From: Matt Holmes [REDACTED]
Sent: 26 April 2019 18:14
To: Anita Gardner
Subject: CM/4/19/PL - Crematorium - Land South of A259 Grevatts Lane, Climping

Stage 1 RSA – Designer's Response

IDENTIFICATION TABLE	
Client/Project owner	Southern Co-operative Ltd
Project	Land at Grevatt's Lane, Climping
Type of document	Stage 1 RSA – Designer's Response
Date	26/04/2019
Reference number	BWREDE17

Road Safety Audit – Stage 1 (Preliminary Design)

Title
PROPOSED SITE ACCESS
GENERAL ARRANGEMENT

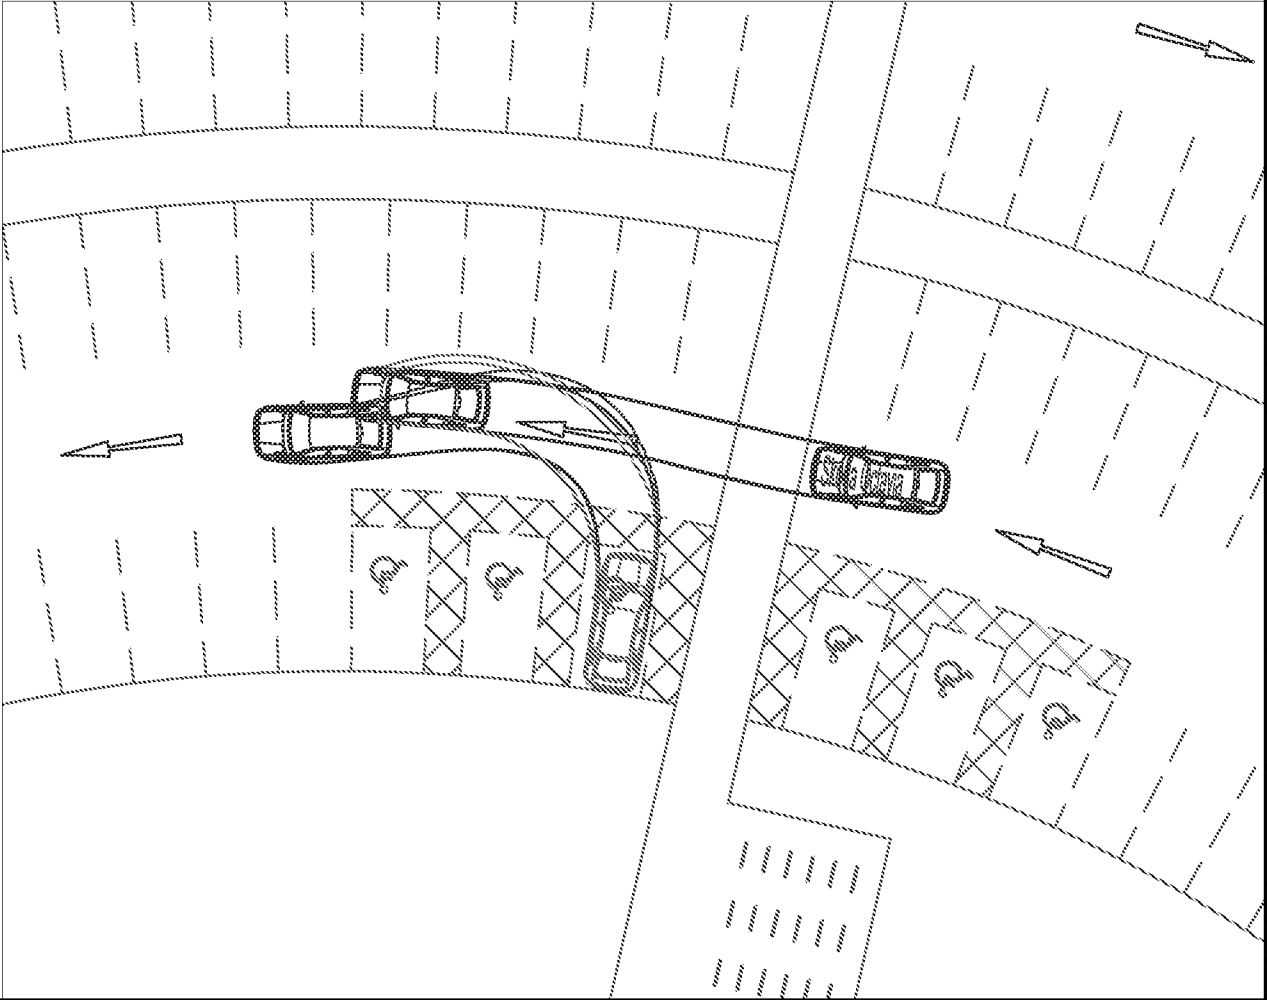
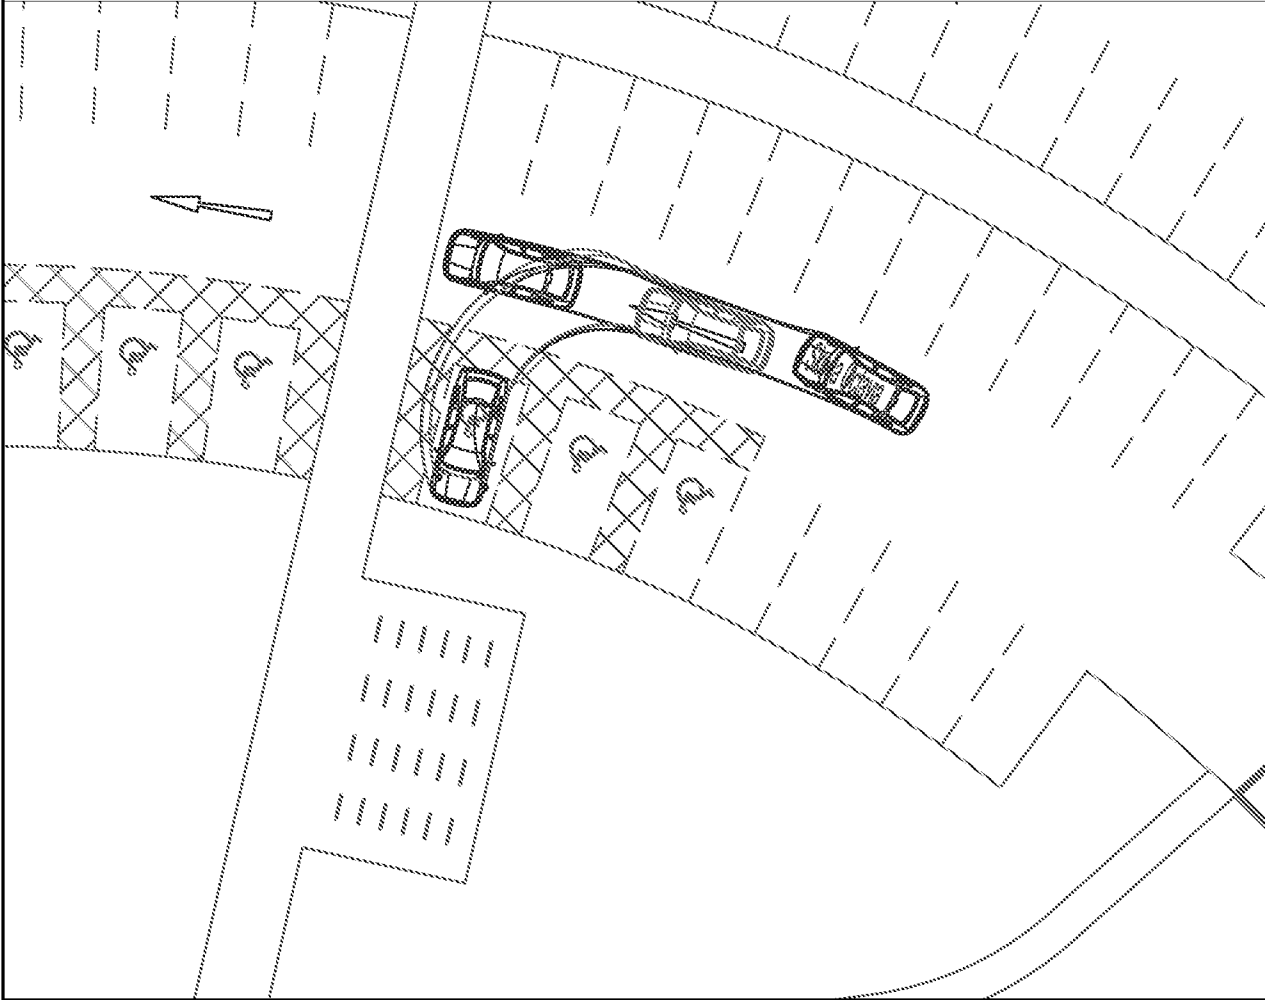
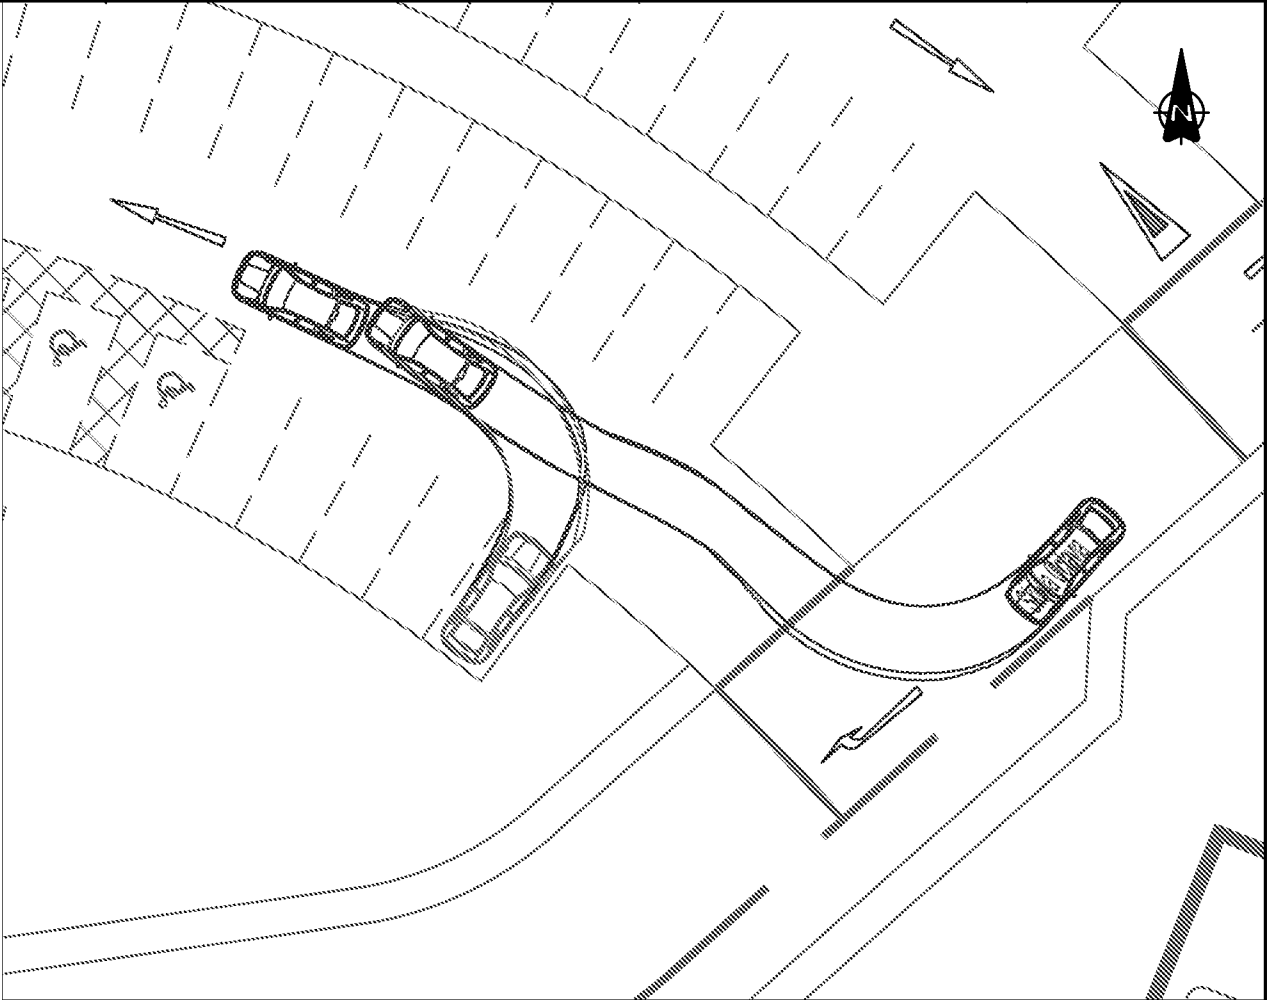
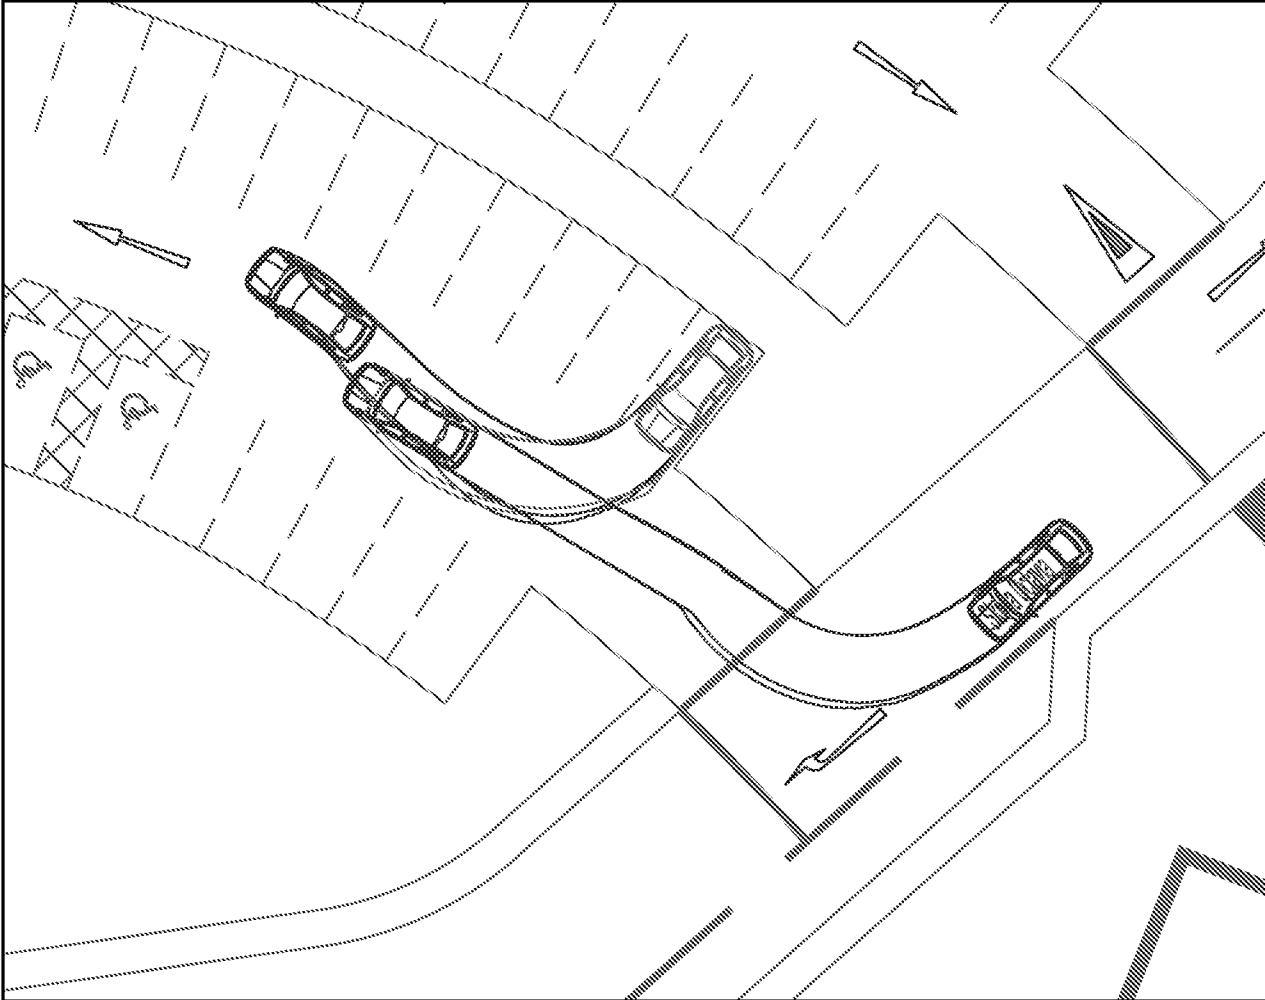
No swept path assessment is provided. The development may attract occasional large vehicles that without sufficient carriageway space may lead to damage-type collisions or collisions with users of the footway if the footway is overrun.

It is recommended that a swept path assessment be undertaken with for the largest typical vehicle anticipated to regularly and frequently visit the site to demonstrate safe and efficient access.

The widening of the carriageway in this location may encourage increased vehicle speeds. Services at the crematorium are likely to be tidal and may involve a greater proportion of elderly drivers. There is potential for risk of collisions between through traffic and turning vehicles.

It is recommended that the speed limit is reduced over this section of highway.

The pedestrian crossing facility may be used by dismounted cyclists seeking to cross from the shared facility on the northern side of the carriageway to the proposed development. There is a risk that cycles may project into the traffic stream where they are at risk of collisions with passing vehicles.

It is recommended that the refuge island is of sufficient width for dismounted cyclists to wait safely with their machines.

- 2.6.1 The existing Grevatt's Lane carriageway measures between 6.8m and 8.3m wide in the vicinity of the site, with existing lane widths of between 3.3m and 4.5m wide (narrowing from west to east). The through-lane widths have therefore been either retained as existing or narrowed over the length of the proposed site access and measure 3.4m and 3.6m wide. This is in accordance with DMRB TD42/95 guidance (Paragraph 7.20) which states that, 'at ghost island junctions, the through lane in each direction shall not be greater than 3.65m wide, exclusive of hardstrips, but shall not be less than 3.0m wide.' The proposed general arrangement drawing has been updated to show the existing lane widths at either end of the junction (drawing number BWREDE-SK01-P5) and is contained in **Appendix E**.

- 2.7.1 In accordance with WSCC's Section 278/38 Highway Agreement Standard Details (drawing no. S278/38/19 Rev D), the proposed refuge island has been revised to measure 2.5m in width and 2.8m in length. This is demonstrated in the updated general arrangement drawing (drawing number BWREDE-SK01-P4) as contained in **Appendix E**.
